From: Madgwick, Will - Communities <Will.Madgwick@Oxfordshire.gov.uk>
Sent: 07 June 2021 10:14
To: Wayne Campbell
Subject: FW: Hook Norton Outline application 21/00500/OUT

From: Mowlem, Daniel - Communities <Daniel.Mowlem@Oxfordshire.gov.uk>
Sent: 03 June 2021 10:19
To: Madgwick, Will - Communities <Will.Madgwick@Oxfordshire.gov.uk>
Subject: RE: Hook Norton Outline application 21/00500/OUT

Phoenix 2-23W (with Elite 2 6x4 chassis)
 Overall Length 11.600m
 Overall Width 2.530m
 Overall Body Height 3.751m
 Min Body Ground Clearance 0.304m
 Track Width 2.500m
 Lock to lock time 4.00s
 Kerb to Kerb Turning Radius 9.250m

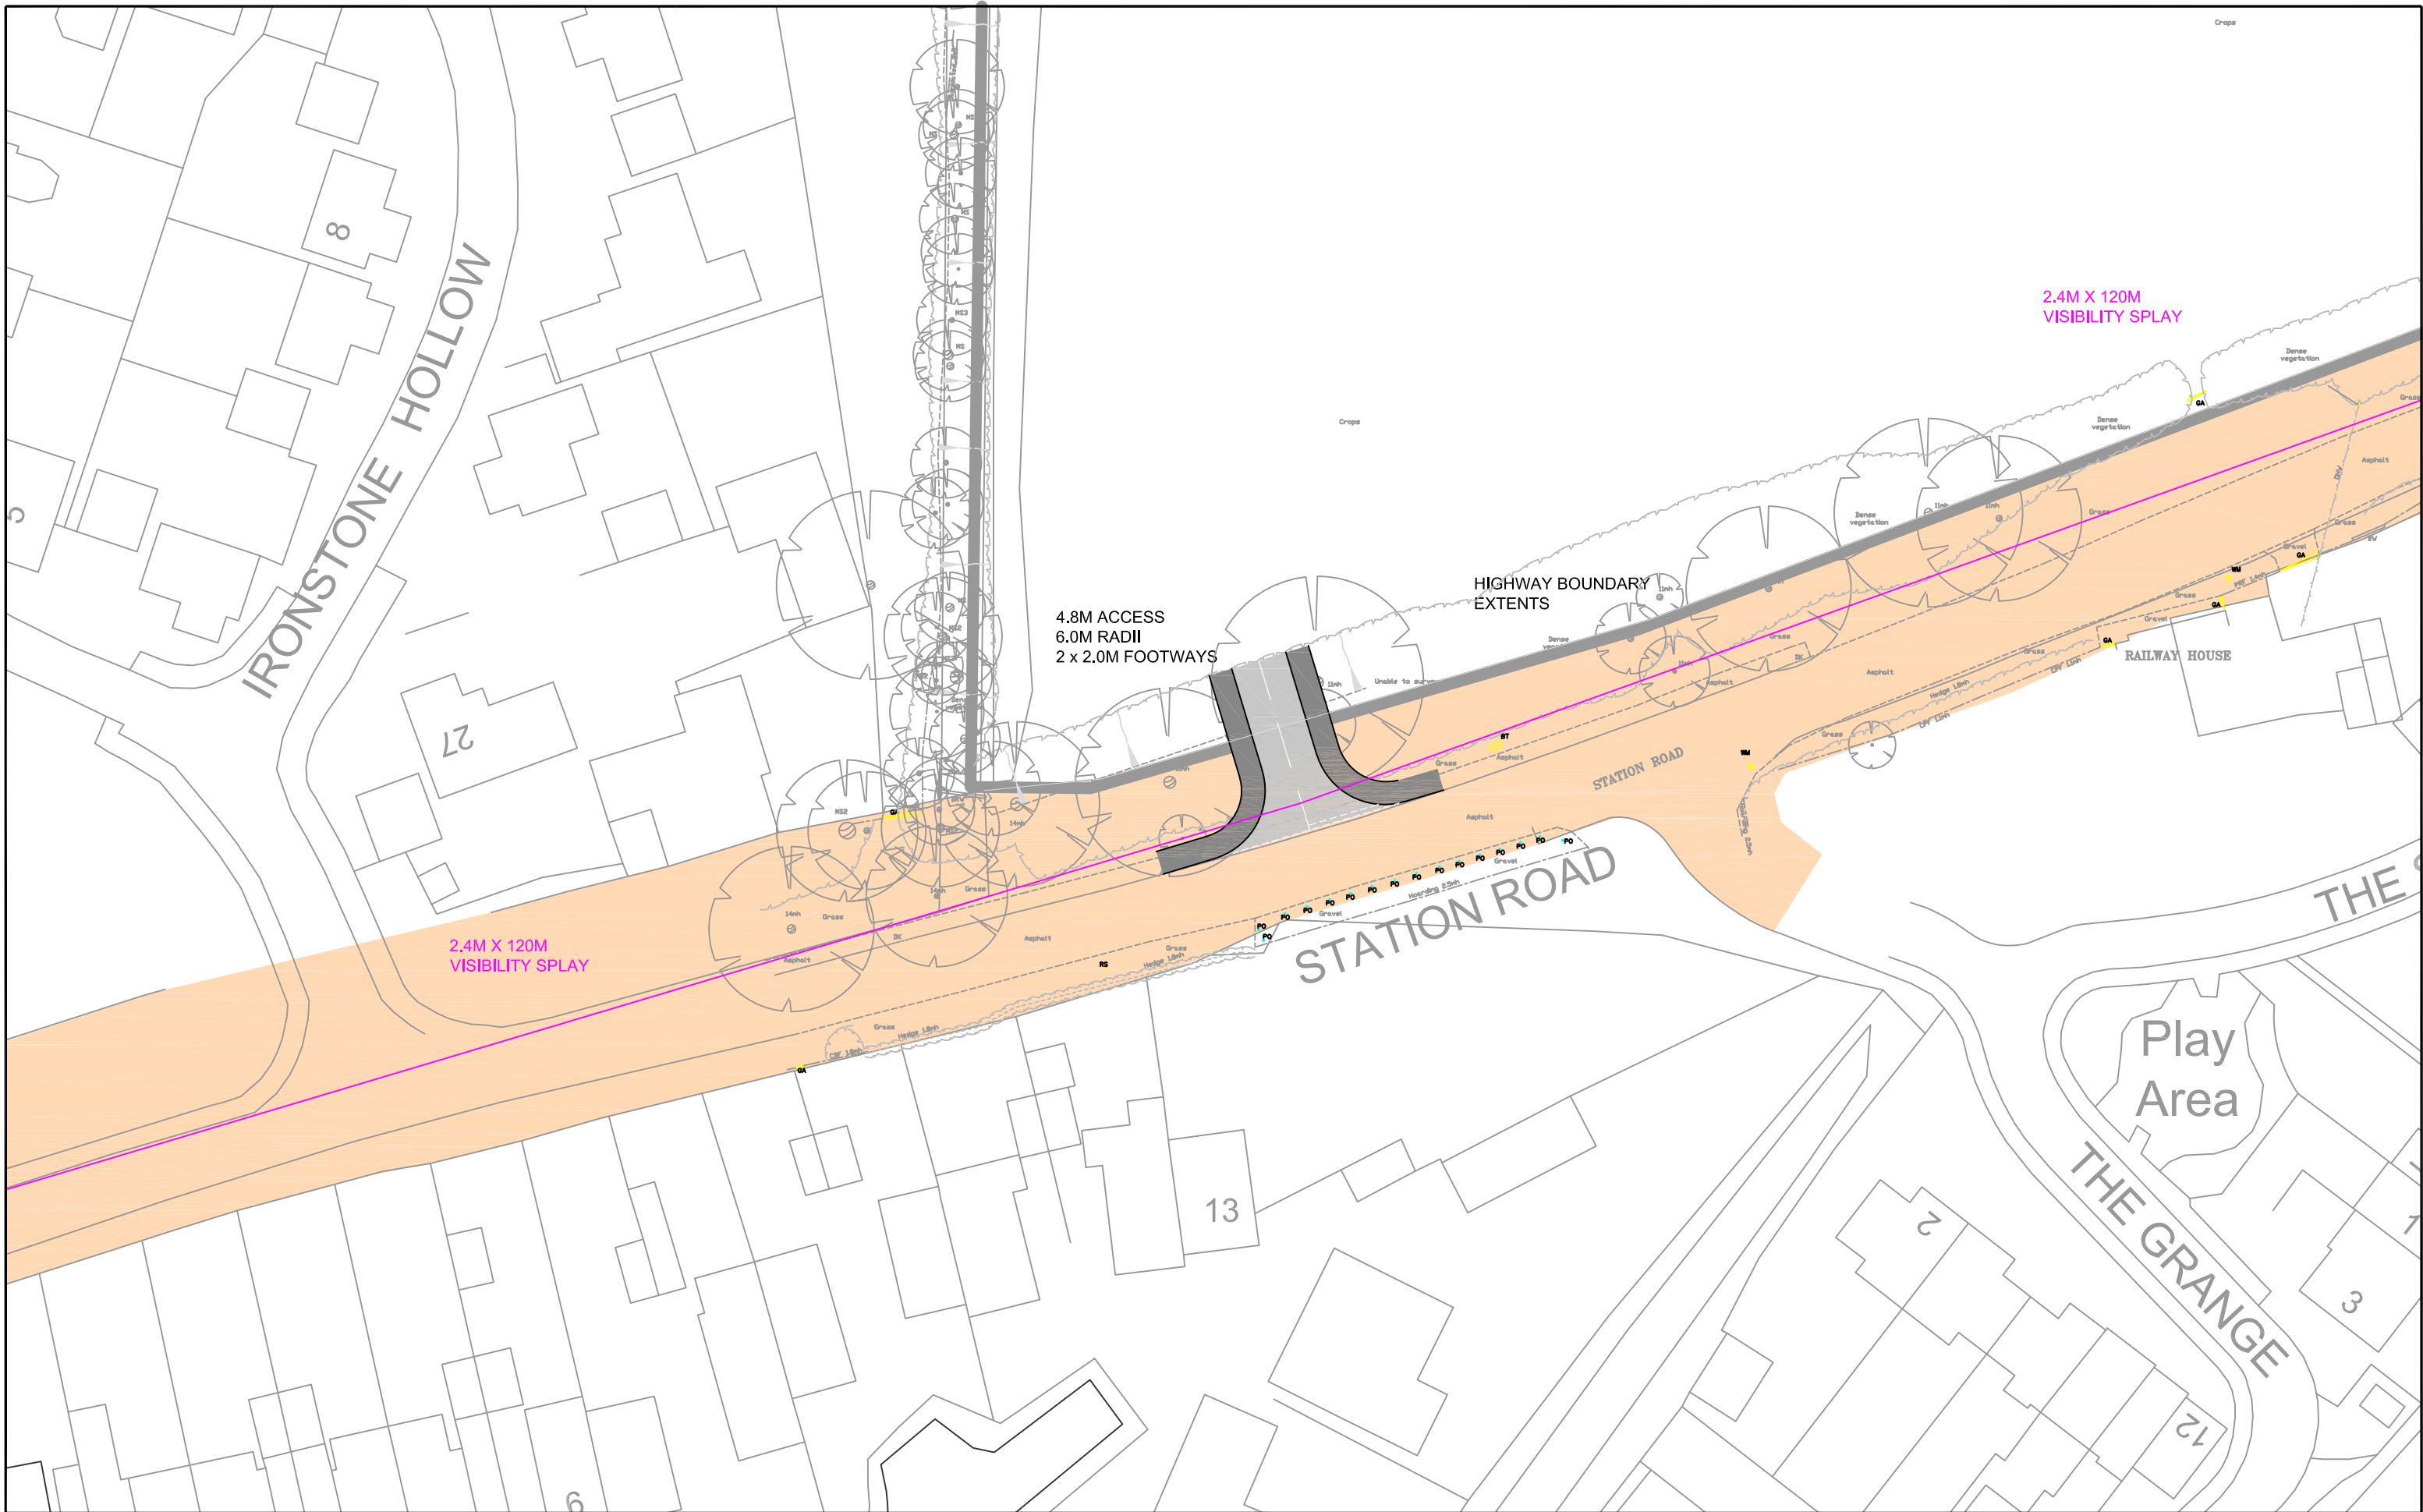
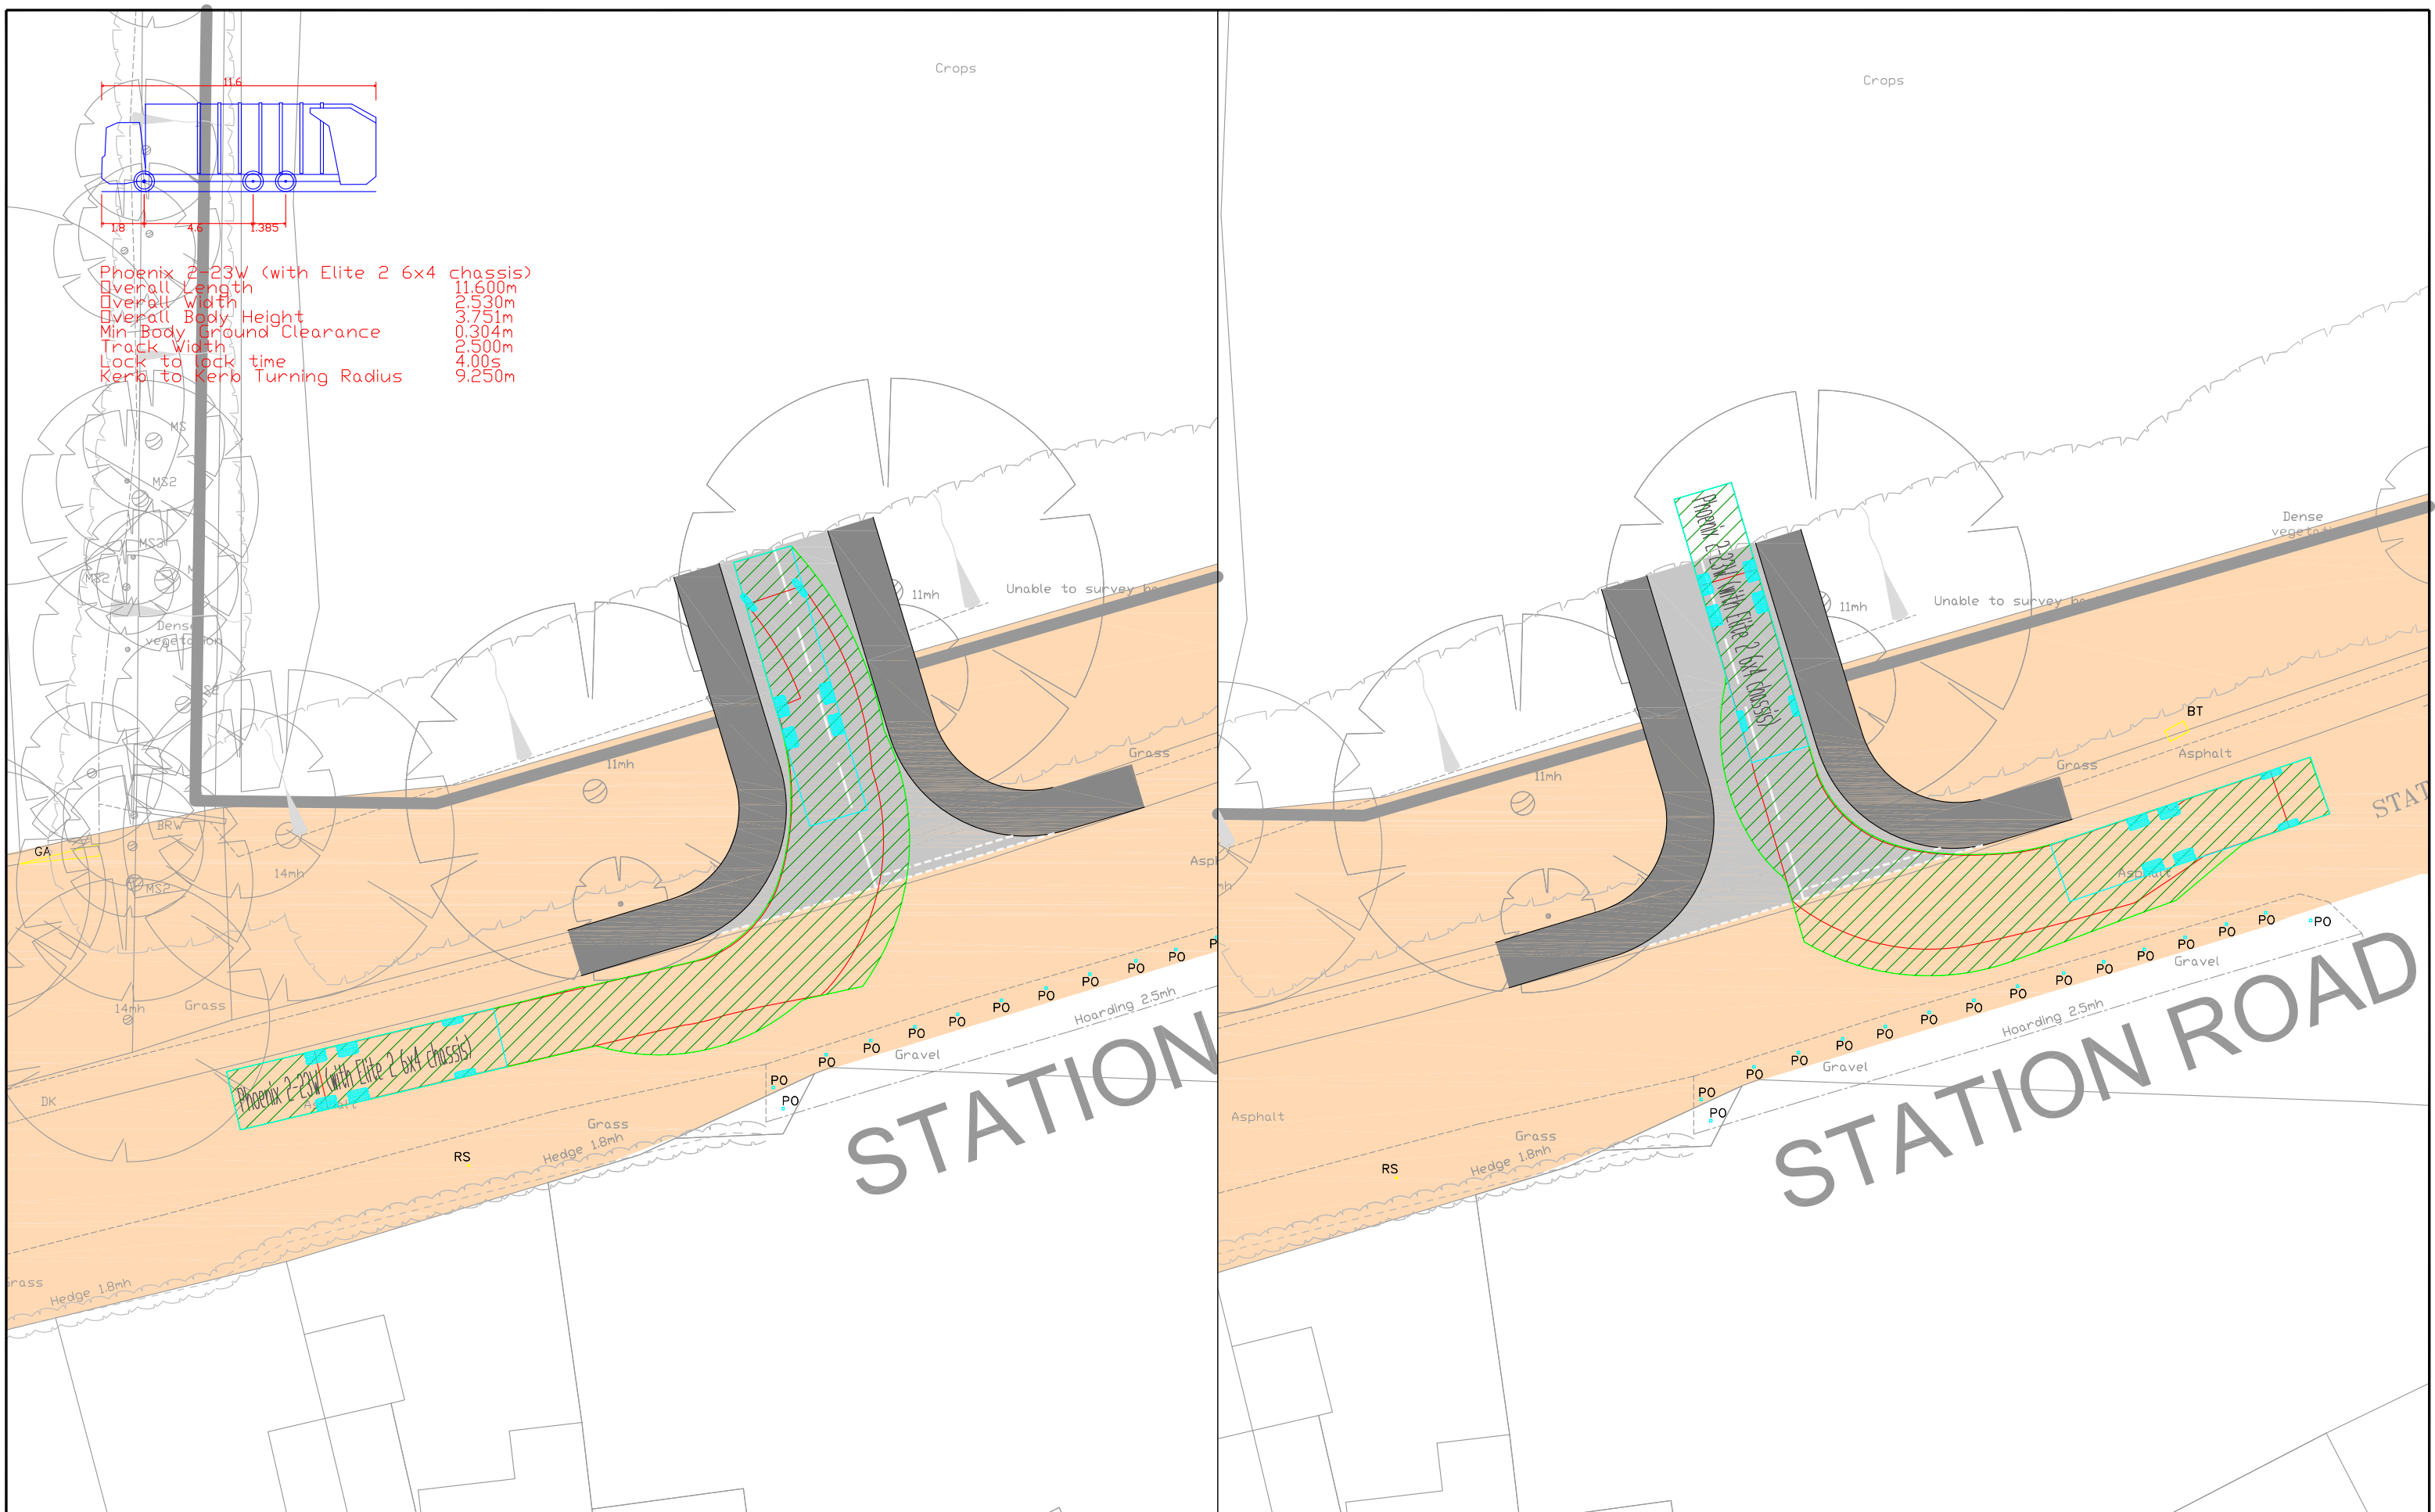
OCC require a swept path analysis for an 11.6m in length refuse vehicle for all manoeuvres in forward gear passing an on-coming or parked family car throughout the layout. The swept path does not indicate how an oncoming or parked car and evidence will be required if this layout is to be adopted. The carriageway will also require widening on the bends as indicated in the OCC Residential Design Guide Second Edition (2015) Para 6.28.
